Your ref:	12 Ulster Terrace	Please reply to:	Mr Gregor Gault
Our ref:	24/00940/FULL	Tel No:	
		Fee Queries:	0207 641 6500;
		Email:	planningreception@westminster.gov.uk;
Ms Sayaka Namba TR STUDIO St Bride Foundation 14 Bride???s Lane London EC4Y 8EQ United Kingdom		Incomplete Applications Town Planning & Building Control City of Westminster PO Box 732 Redhill, RH1 9FL	
			19 February 2024

Address: 12-12A Ulster Terrace, London, NW1 4PJ,

Proposal: Installation of two air source heat pumps in basement car park, and installation of new louvre ventilation grille on rear façade. [Linked to 24/00941/LBC]

1 Existing Facade Elevation with Demolition - South East  
Scale: 1:100

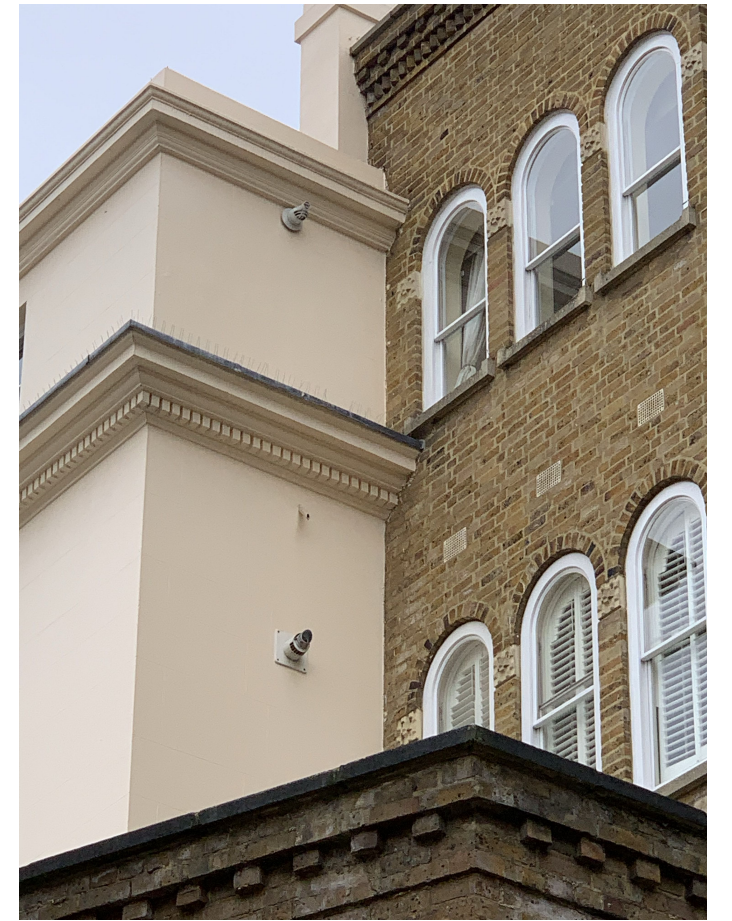
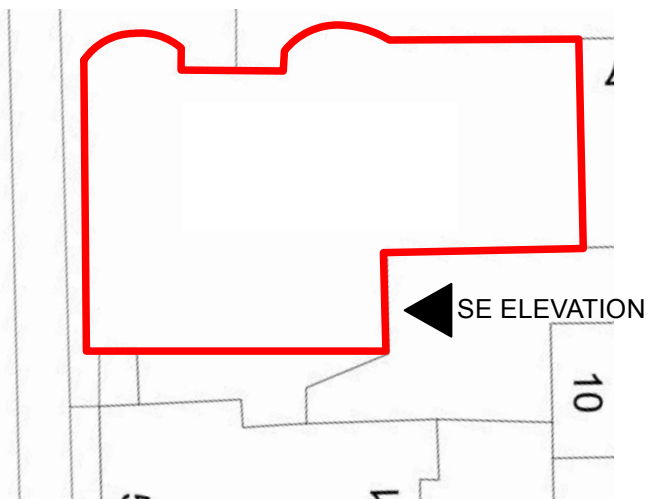
- existing and proposed rear (south east) elevation drawings showing the proposed louvre grill.
